WEST SUSSEX COUNTY COUNCIL CONSULTATION

TO:	Arun District Council FAO: S Davis
FROM:	Highways, WSCC
DATE:	13 th November 2018
LOCATION:	Land West of, Fontwell Avenue, Eastergate, PO20 3RU
SUBJECT:	AL/116/18/PL Variation of conditions 2, 10, 11 & 12 imposed under AL/121/16/PL relating to the substitution of plan SP01 RevA with SPO1 RevB (proposed site plan).
RECOMMENDATION:	☐ Advice ☐ Objection ☐ Modification ☐ No Objection ☒ More Information ☐ Refusal
S106 CONTRIBUTION TOTAL:	£N/A

C/No. 215818	D/No. 1/500 @ A?	SCALE 1/500 @ A?
DRAWN EW	DRAWING NUMBER SP01	REV B
DATE 10/16

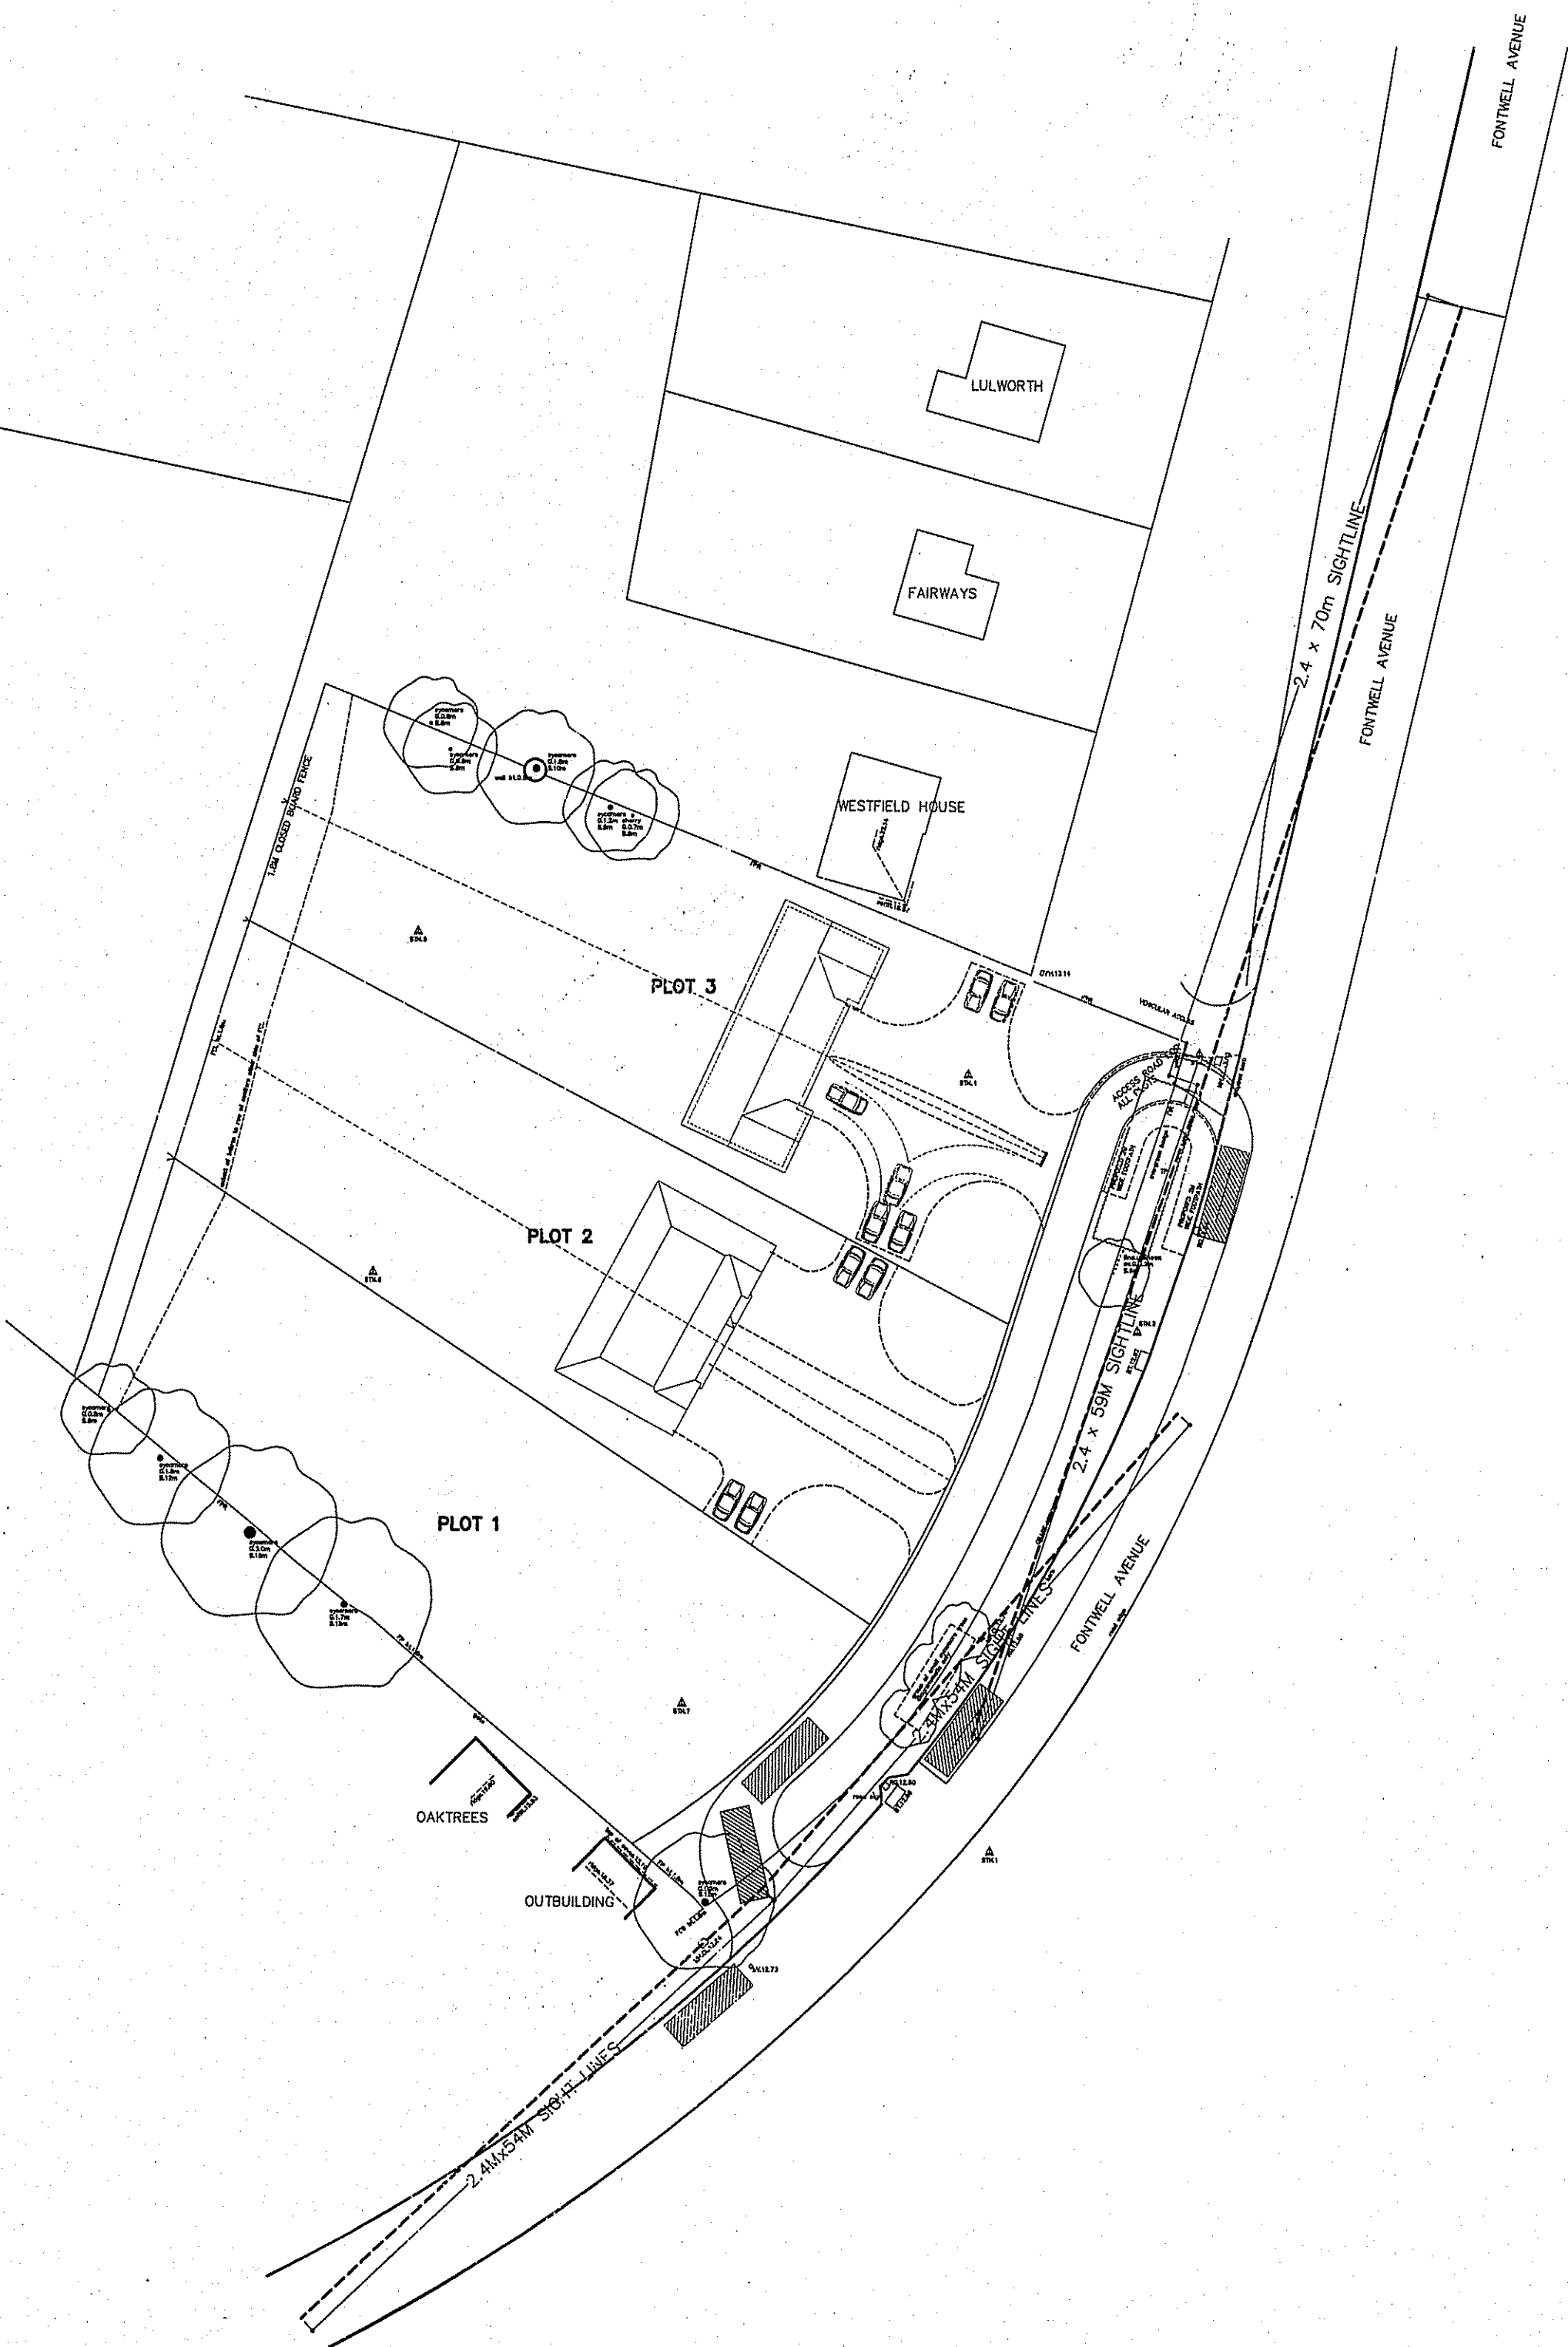
The variation of condition relates to the substitution of Site Plan SP01 RevA with SP01 RevB to allow for revisions to vehicle access and turning as approved under AL/136/17 whereby a second access to the south was permitted to allow an in/out arrangement and omit the need for a turning head.

Under AL/136/17 vehicular visibility splays of 2.4m by 59m were provided from the centre of the proposed southern access, extending to the nearside carriageway edge. As per previous comments these splays were considered suitable and in line with recorded vehicle speeds. Splays of 2.4m by 54m to the centre line in either direction have been provided on the amended site plan. This is not in line with the access approved under AL/136/17. Splays of 2.4m by 59m should be demonstrated from both access points and in both the north and south directions; these should not pass through third party land and should extend to the nearside carriageway edge.

The previously approved footway link and pedestrian crossing (tactile paving) points have also not been satisfactorily demonstrated on the revised site plan.

Please ask the applicant to amend the plan ensuring that visibility splays, within the red edge of the site and publically maintained highway, are accurately plotted as per comments above and that the approved footway link is also represented.
